Application No: EP/93/15/HH

Recommendation Report for Planning Permission for Works or Extension to a Dwelling

LOCATION: 14 Worthing Road
East Preston

PROPOSAL: Single storey wrap around extension to provide annexe

PROPOSED FLOOR PLANS 1:100

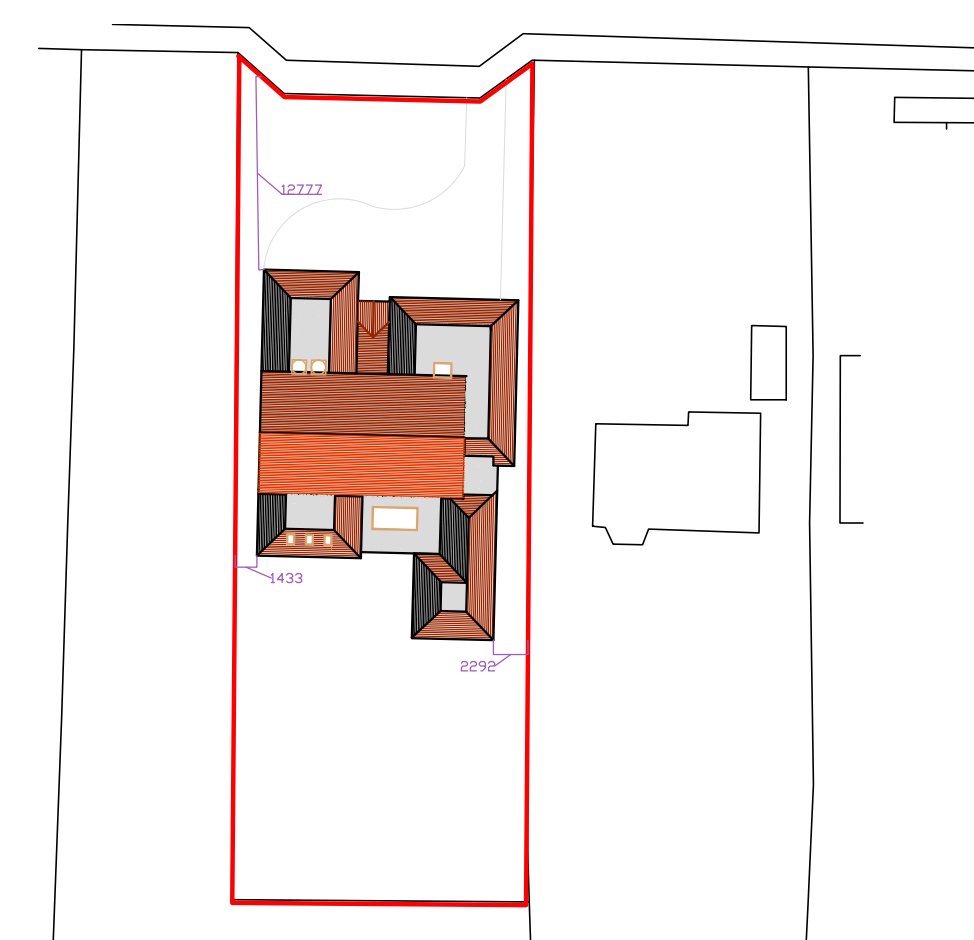
The footprint of 6 dwellings is less than the proposed footprint, the extension does not visually accord with no16, will severely restrict sunlight to neighbour, there is a reduction in the overall space to the neighbour's boundary. No properties in Worthing Road have whole site width front parking, view from Langmeads to the rear will be adversely affected by piecemeal roof forms, the prefabricated garage is not shown on the submitted existing ground floor plan, adjacent property is 70cm lower at the front and 40cm lower at the rear of the proposed extension and extension will be overbearing, the building is effectively 2.85m nearer, proposal will have windows in the east elevation which will result in overlooking, is covered walkway to be retained? The increase is 49.89% (119.13 sq m).

Comment on other objections - The proposal does not significantly increase the footprint of the existing dwelling and extensions. The floor area as existing is 249 sq m the proposed is 354 sq m. This represents an increase of 42%. The proposals do not extend the full width of the site. The new design reduces the overall width of the present buildings. The extensions would not be readily visible from the recreation ground being screened by boundary walling and planting. There is no proposal to increase the parking area to the front of the site. The single storey extension would be located 1m from the boundary and extension would have an eaves height of 2.1m and a ridge of 3.3m. It would therefore not project significantly above the boundary wall and would not have a materially adverse overbearing impact on the adjoining property.

SIDE ELEVATION
East
PROPOSED ELEVATIONS 1:100

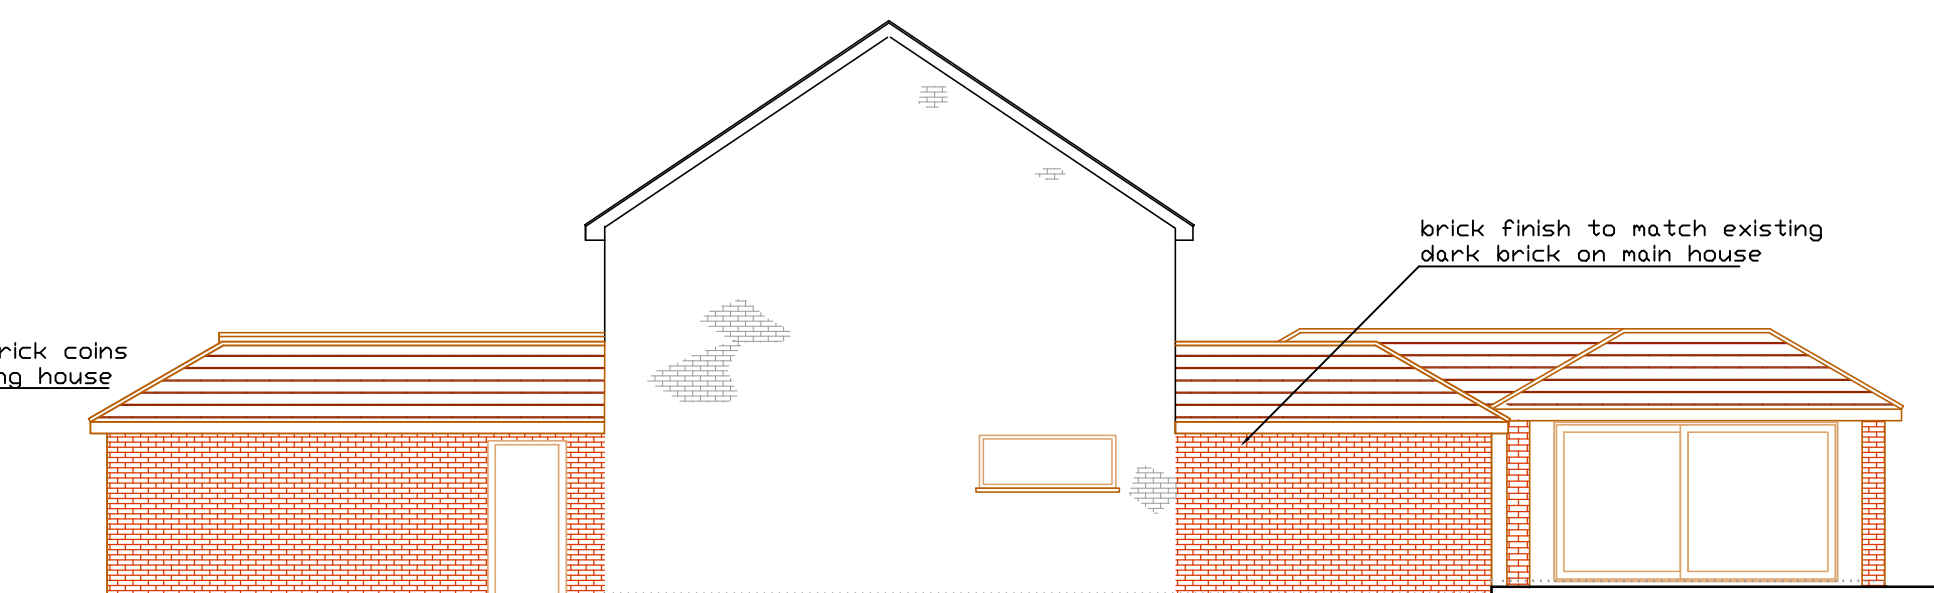
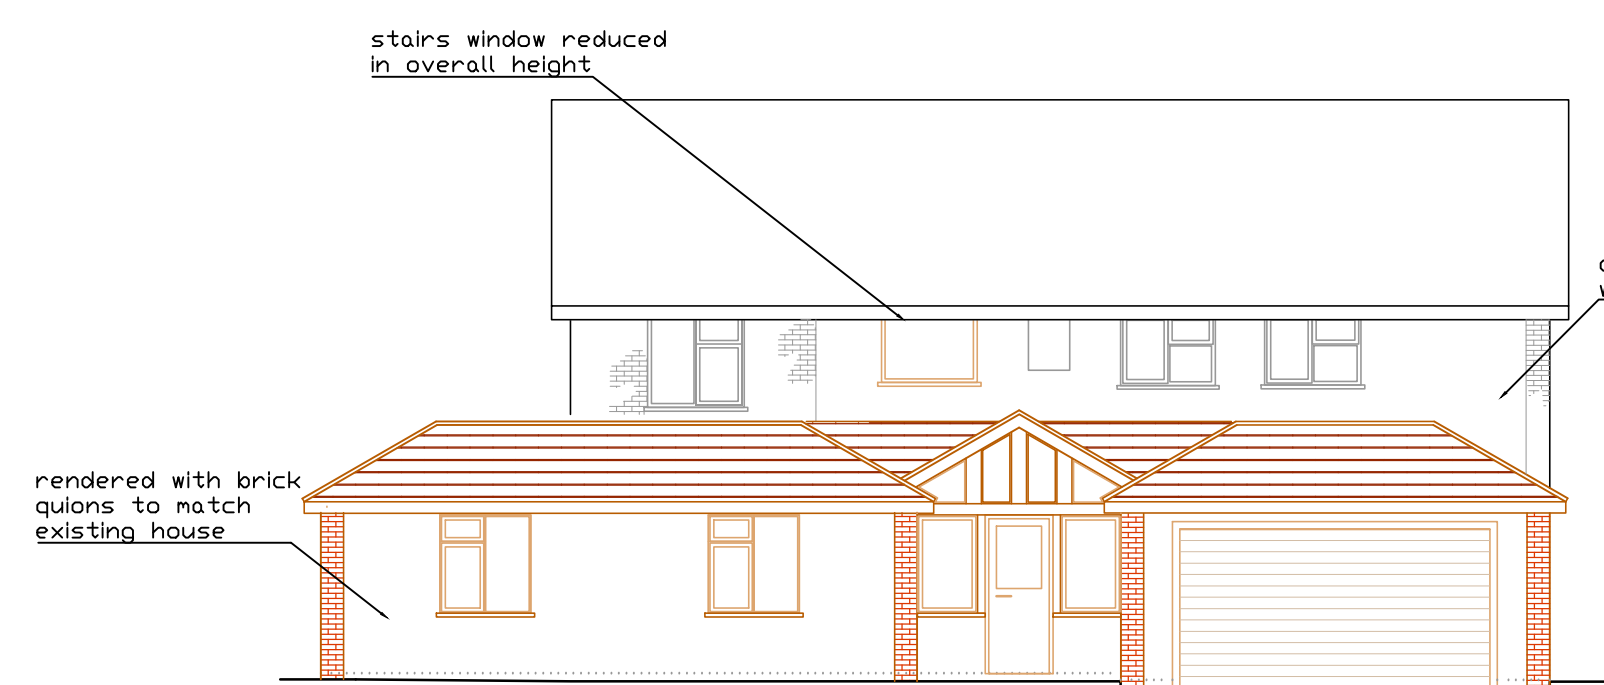
Objection - Proposal is contrary to East Preston Neighbourhood Plan. Section 4.16 of the Plan states 'Extensions should be designed to look as if they were part of the original; design of the house.' The proposal does not. The extensions would be better placed at the rear. The proposal would have an overbearing design which may increase overshadowing of the property to the east.

One letter of objection from adjoining neighbour's agent. The proposal would more than double the footprint of the dwelling. The proposed building would fill the width of the site and project substantially at the front and rear. It would constitute a sprawling structure and would not represent high quality design and layout. The scale would be inappropriately large in relation to the dwelling. The extensions would dominate and would not be subservient. The development would be out of keeping with a 6.5m projection in front of the main house. The form and proportions of the dwelling would be lost to the detriment of the appearance of the dwelling. The extensions would be visible from the recreation ground to the rear. The increase in parking to the site frontage and loss of greenery would adversely affect the character of the area. The section of rear extension closest to 16 Worthing Road would project about 7.5m beyond the rear wall of 16 Worthing Road. This would create an expanse of blank brick wall to no 16. This section would be higher than others and would extend up to just above sill level of the first floor windows of the application property. This would be overbearing on the outlook from the dining room bay window and in the rear garden of no 16. The sitting room and garden currently enjoy an open aspect to the west and the proposed extension would be oppressive. Sunlight would be reduced in the afternoon and evening to the detriment of neighbour's amenity.

The proposed works by virtue of their single storey nature and sloping roof profile together with dense boundary planting located in number 16 to the front and side of the dwelling and a 2m high solid wall to the rear of the property will ensure that there will be no unacceptable impact on neighbouring amenity by way of visual intrusion and/or loss of light.
